**PROJECT: MEADOWBANK SCHOOLS PROJECT**  
**RE: SDRP SESSION 01 - 02.05.18**

**PROJECT: MEADOWBANK SCHOOLS PROJECT**  
**RE: SDRP SESSION 02 – 13.06.18**

PROJECT: Meadowbank Public School, Meadowbank  
RE: SDRP SESSION 24 – 06.02.19 (fourth review)

PROJECT: Meadowbank Public School, Meadowbank  
RE: SDRP SESSION 27 – 27.03.19 (fifth review)

GROUND LEVEL

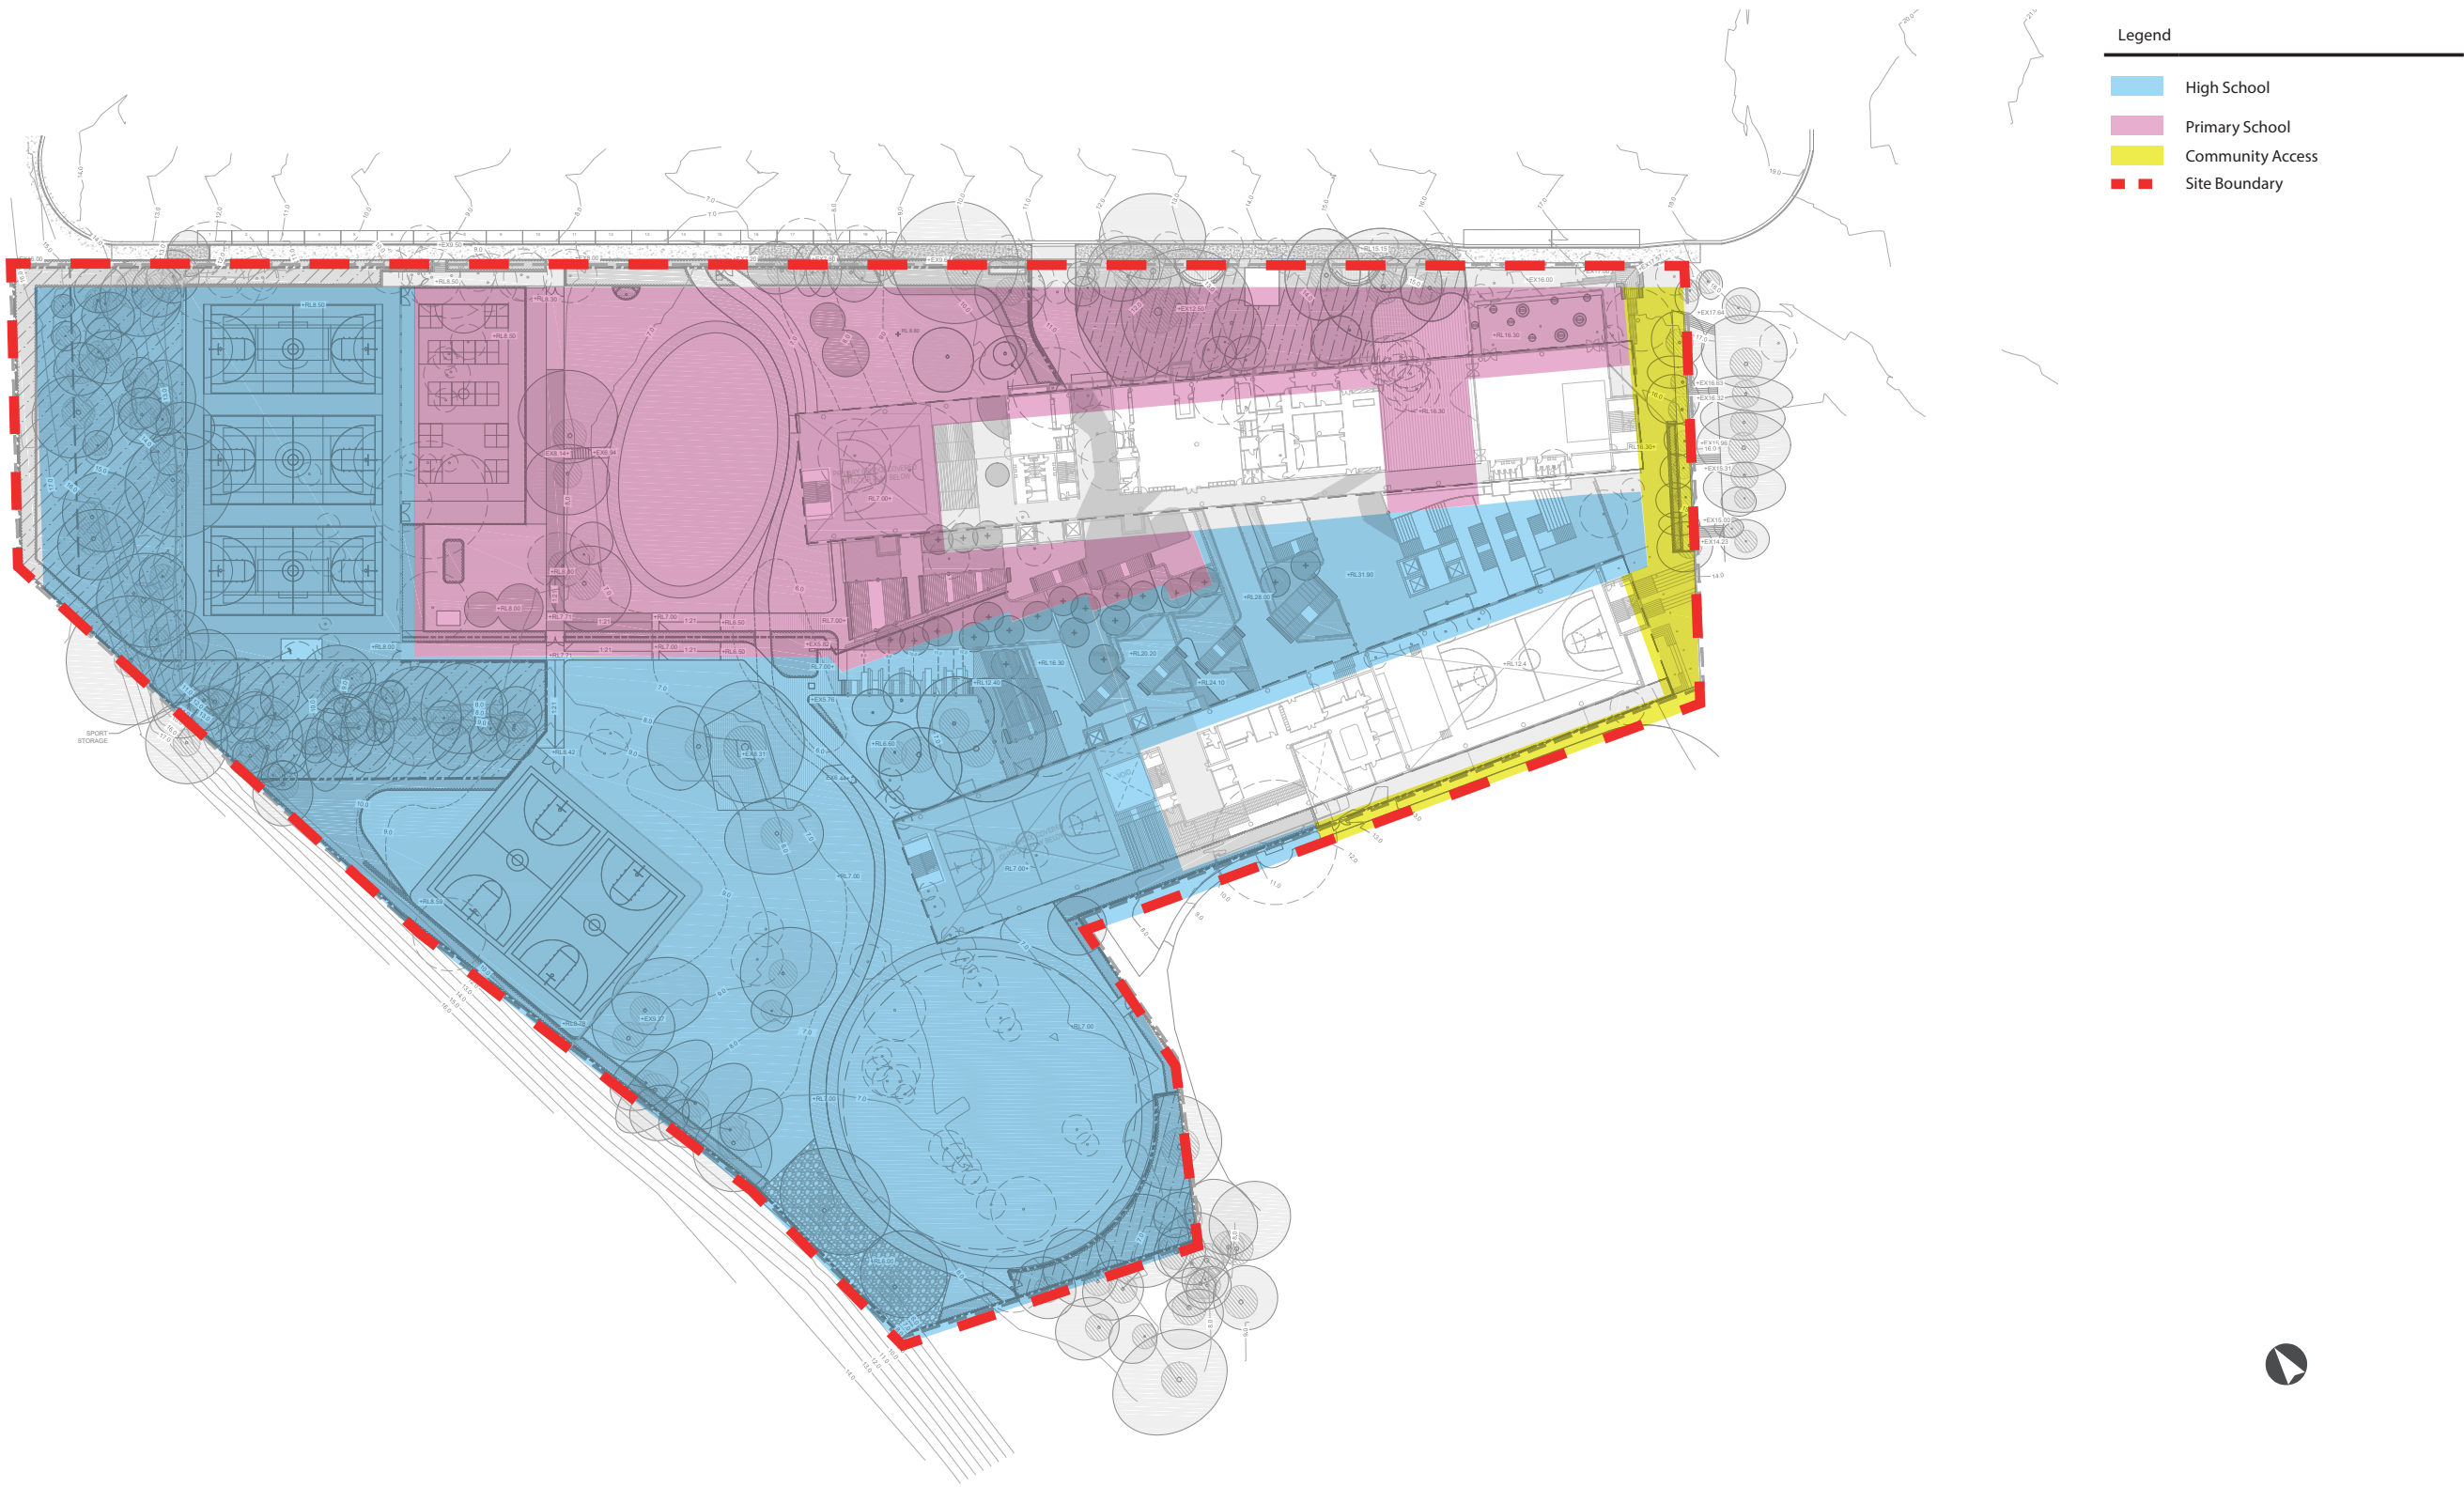
- Further detail as to the integrated fencing and landscape, which is supported in principle;
- Consideration of the grade and design of ramping in order to eliminate the need for handrails, balustrades and excessive landings - including to trafficable roofs.
- Detailed information demonstrating coordination of the existing topography, landscape features, setbacks to protect trees and flood level constraints. This may include integration of existing or new trees or planting within architectural forms in consideration of biophilia opportunities.

- clear approach to retaining or removing existing trees and proposed new trees on the site
- integrated fencing and landscape strategy;
- detailed plans and sections demonstrating coordination of landscape and architectural strategies noting topography, landscape features, setbacks and flood level constraints. This may include integration of existing and new trees and integrated façade planting.
